Rezoning Transportation Analysis

Petition Number: 2023-002

Date	Description
5-24-23	First Review (IW)
6-13-23	Second Review (DR)

RZ-1

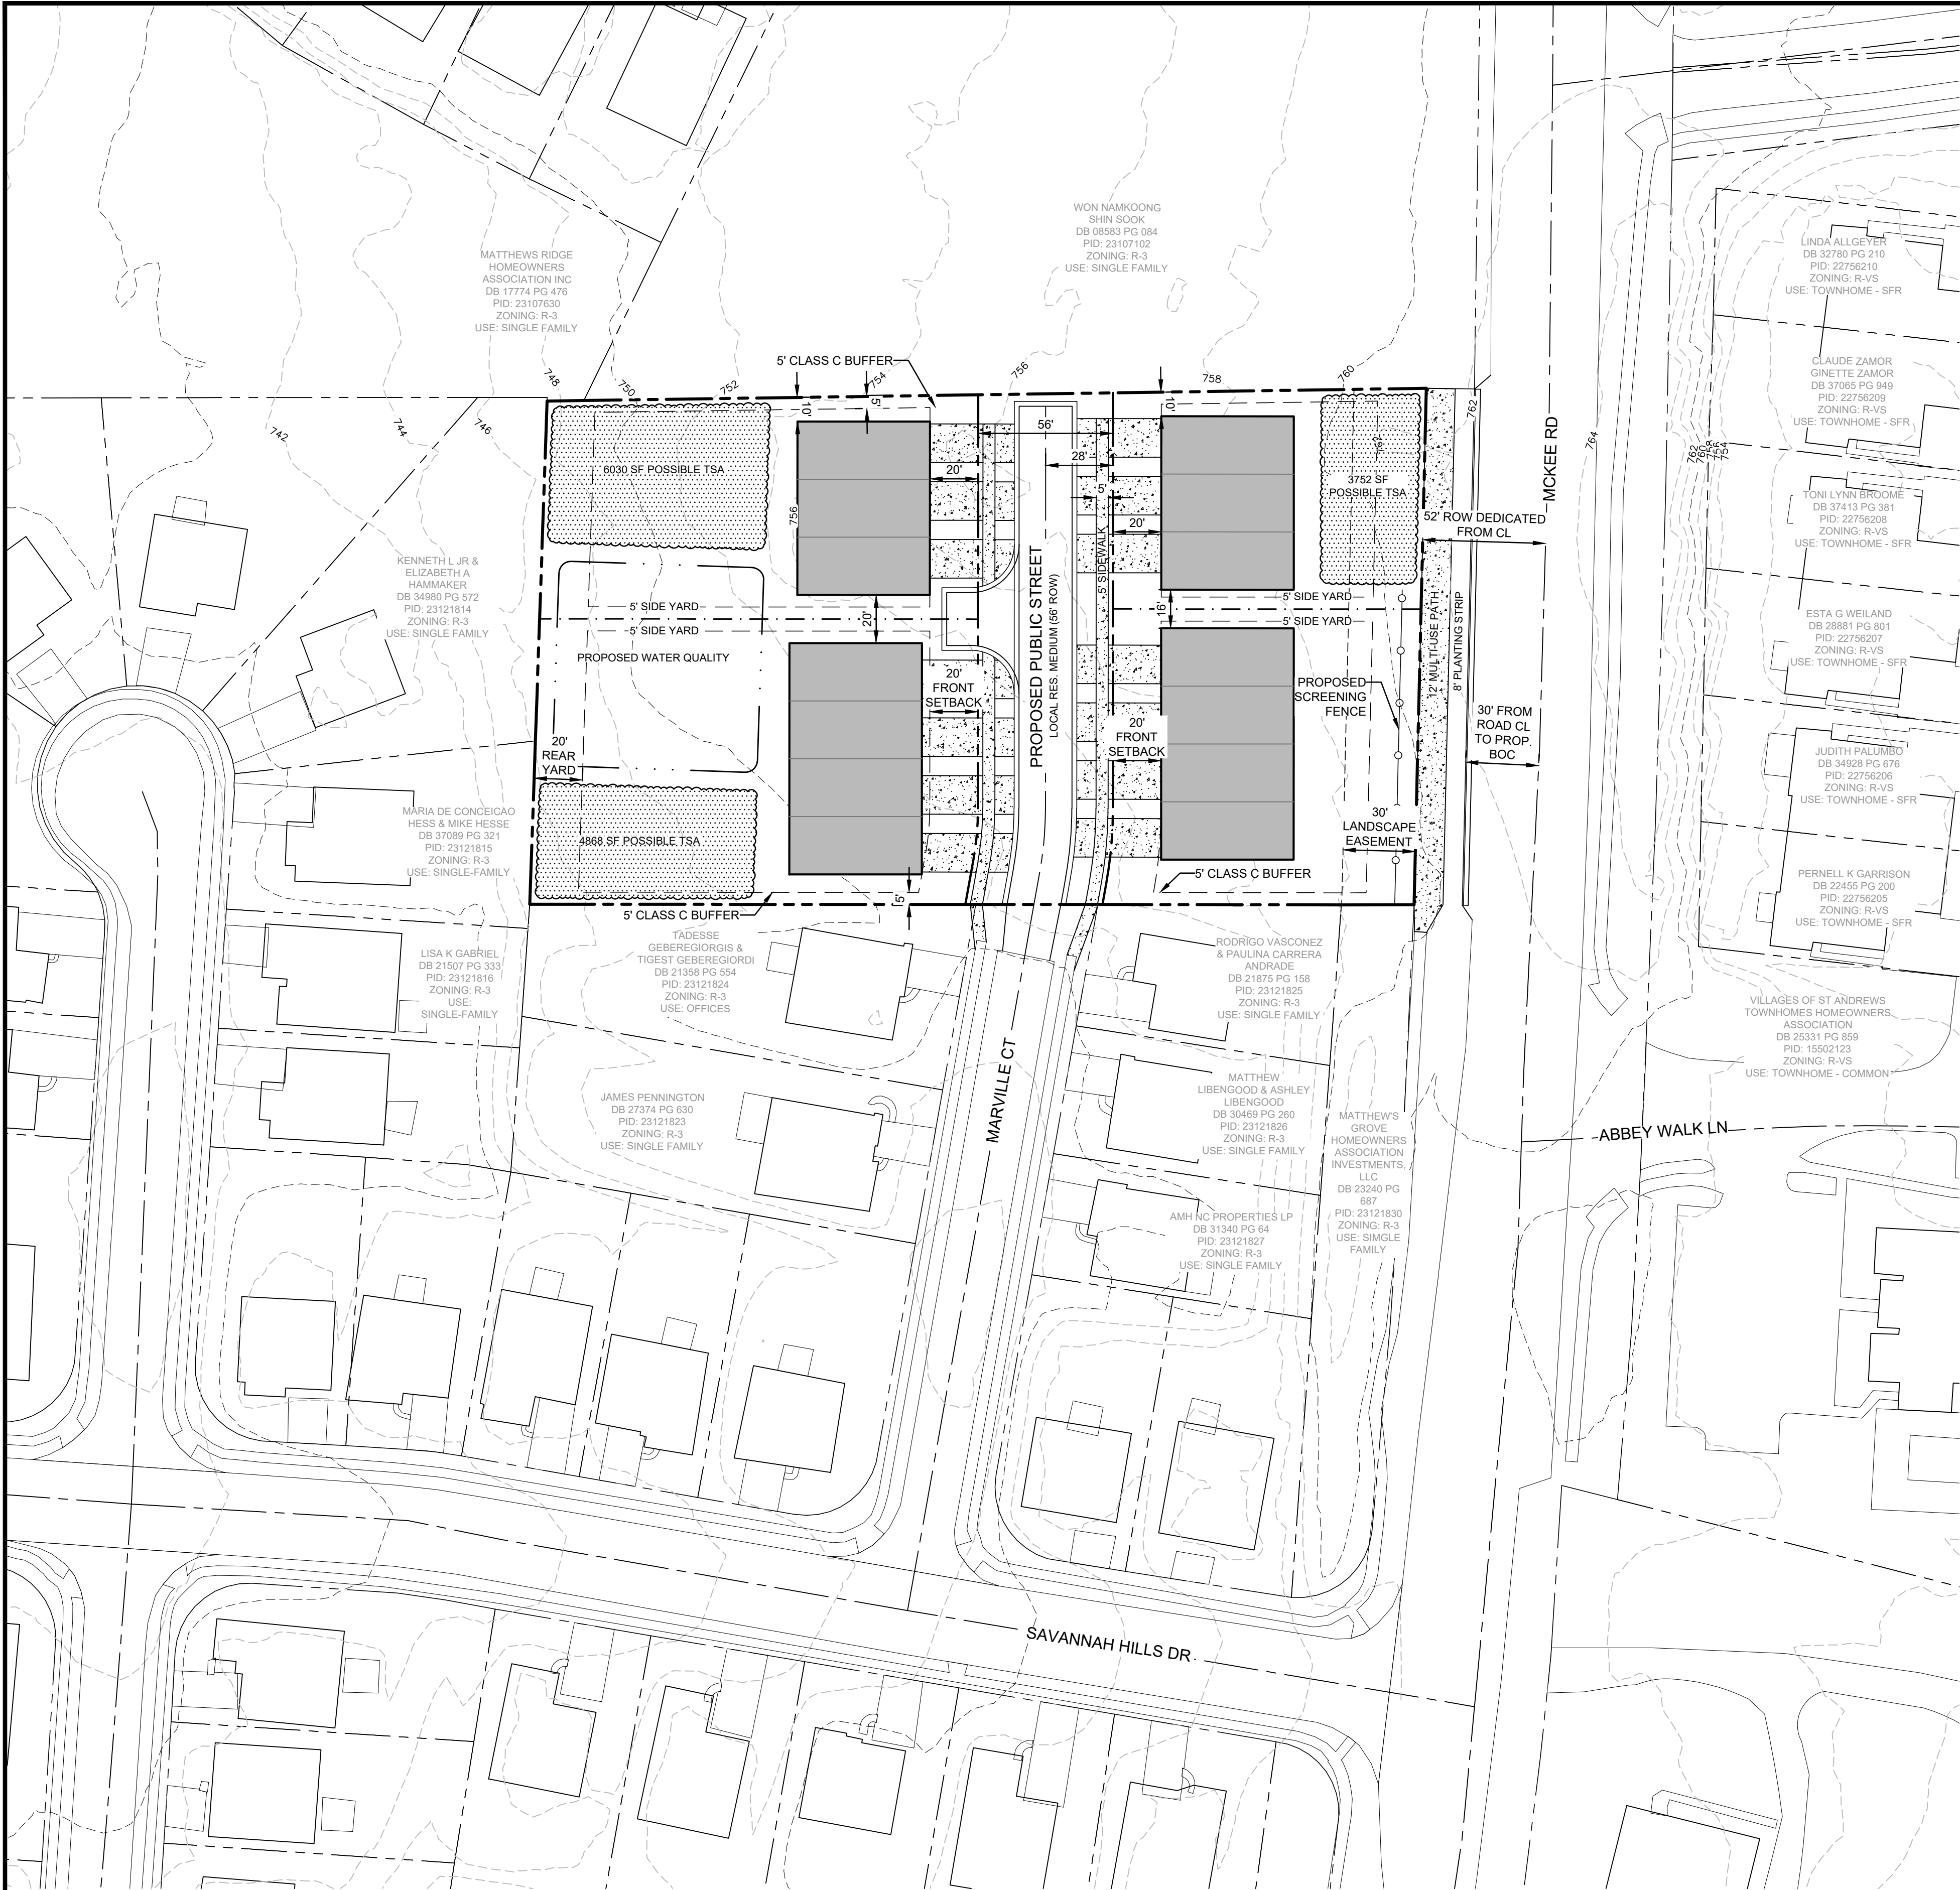
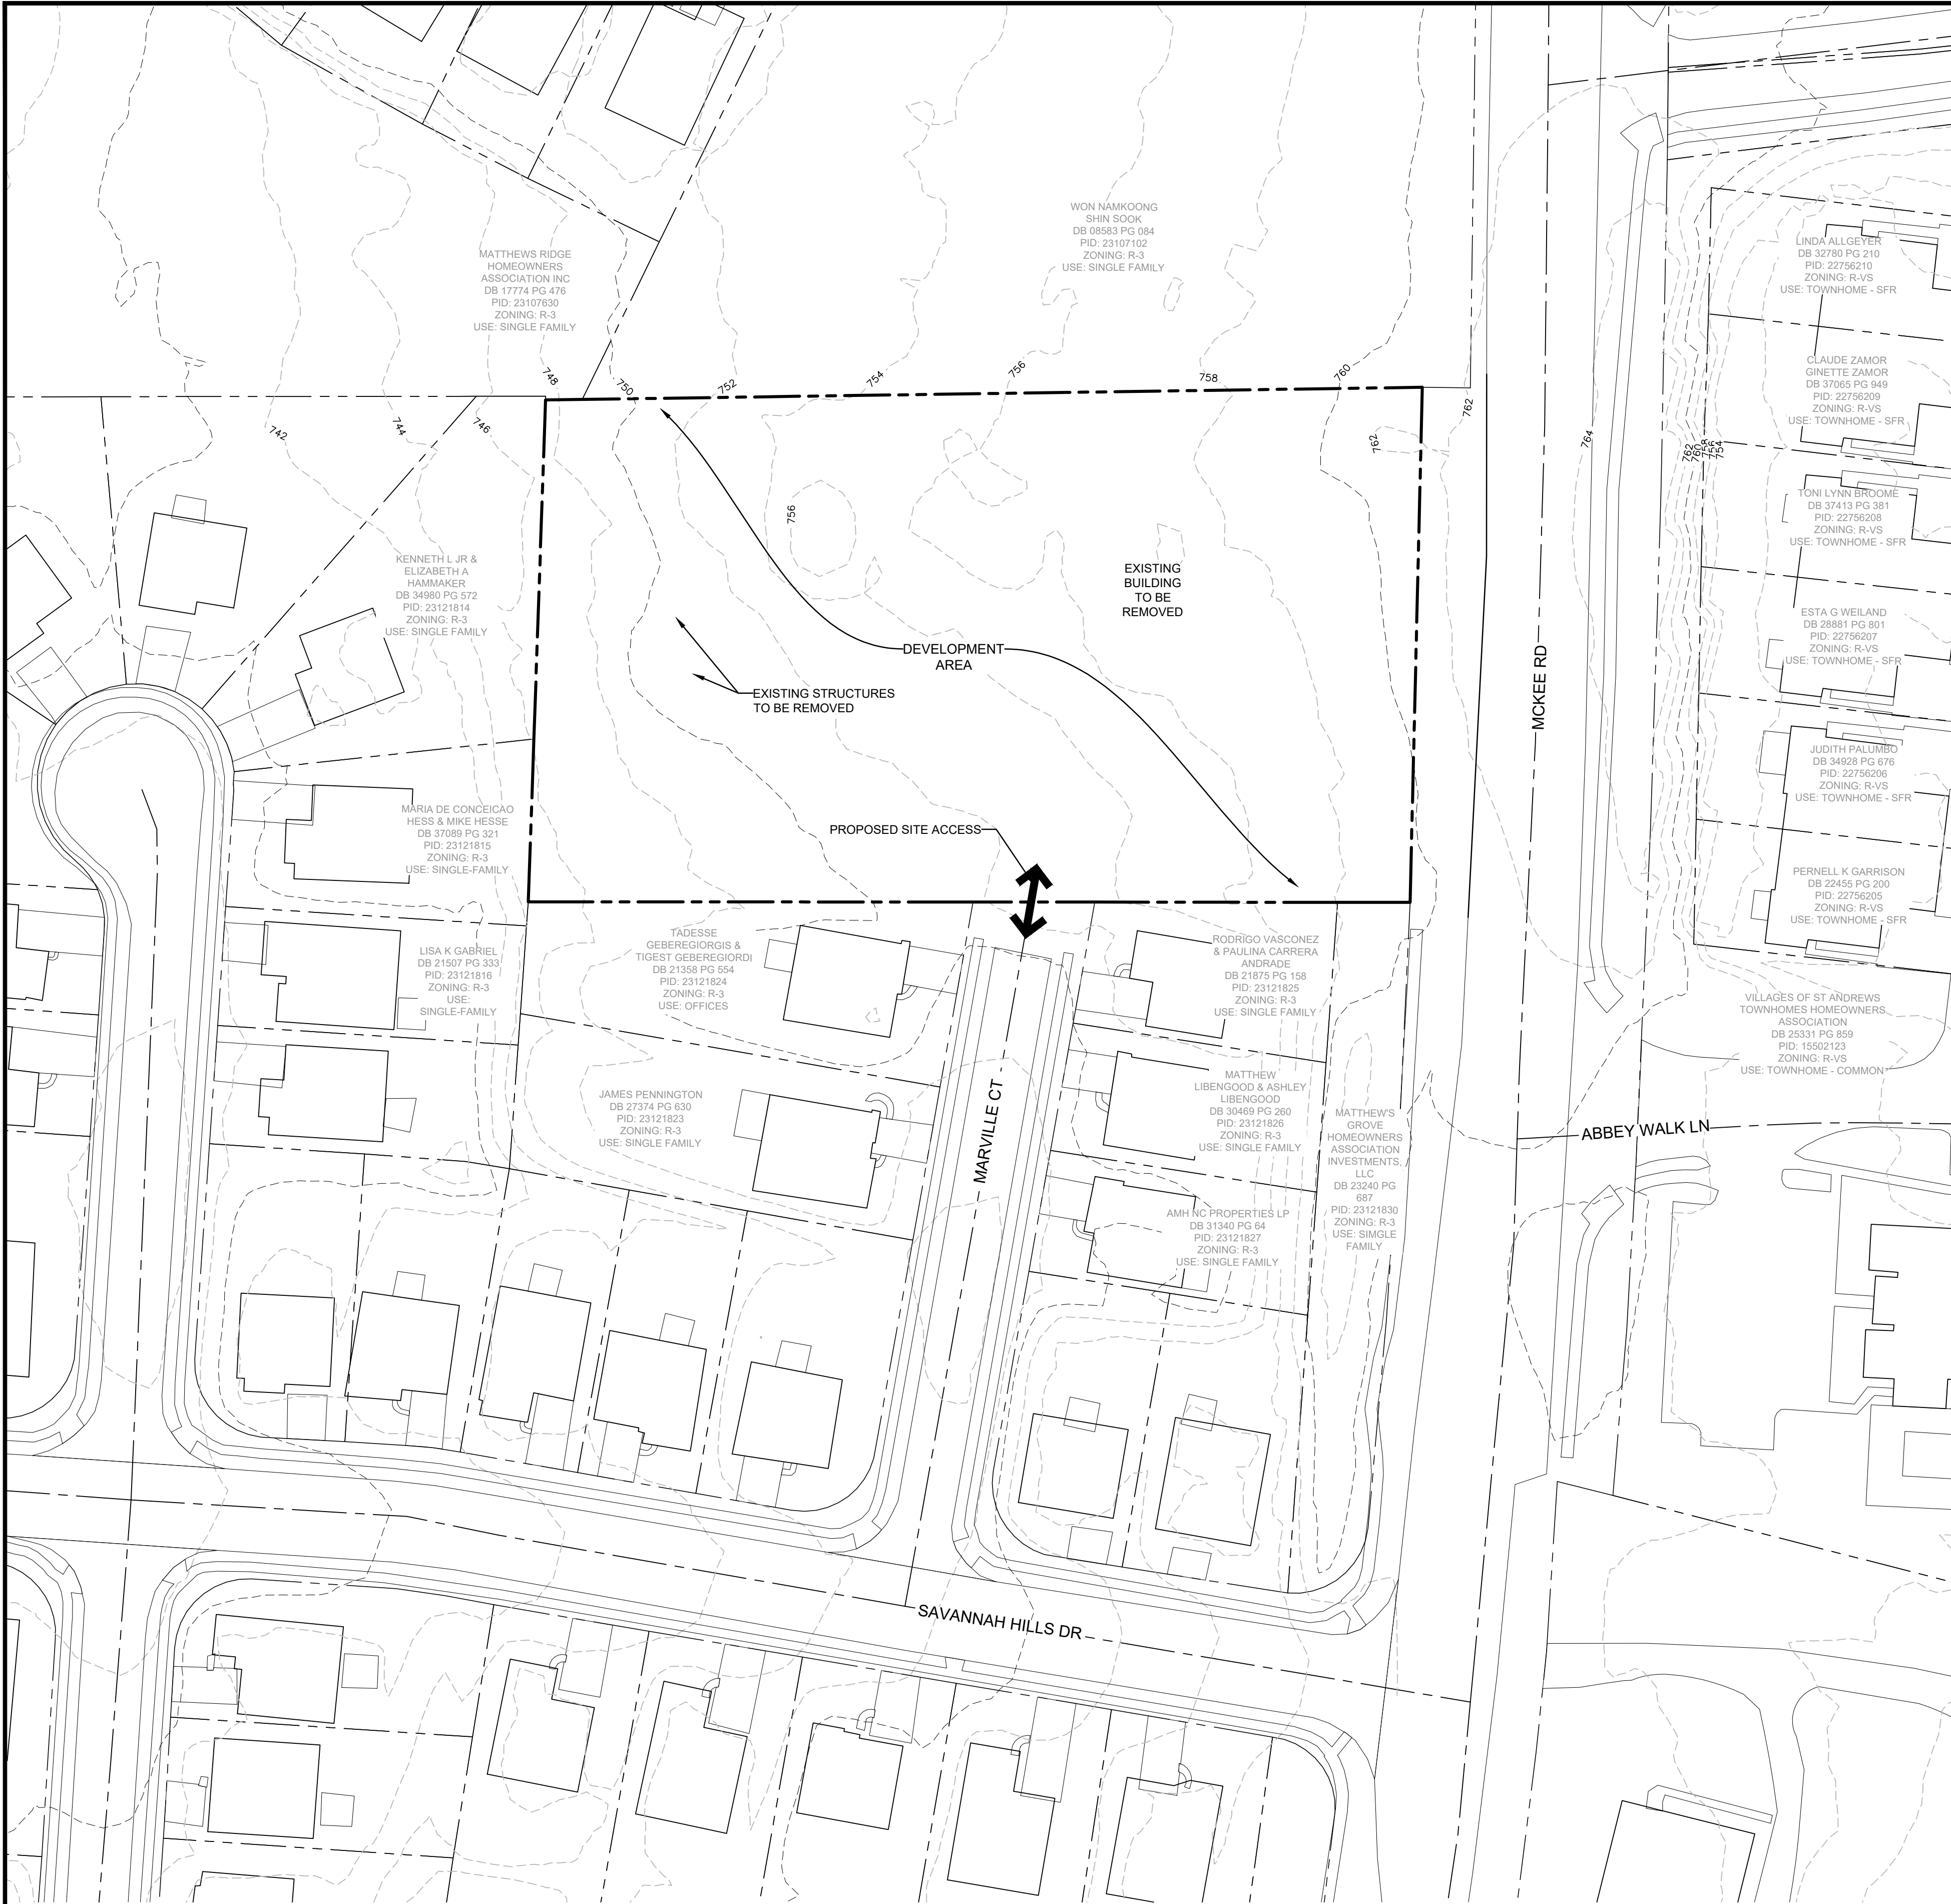
- a. ~~McKee Road: Future location of curb and gutter to be 30 feet from roadway centerline to accommodate the Charlotte Streets Map with a roadway typical section of 4+ Avenue.~~

~~Label and dimension the curb and gutter from the centerline for each road on the site plan.~~

4. ~~Revise site plan and conditional note(s) to commit to better align Marville Ct with road extension by extending the curb and gutter as well.~~
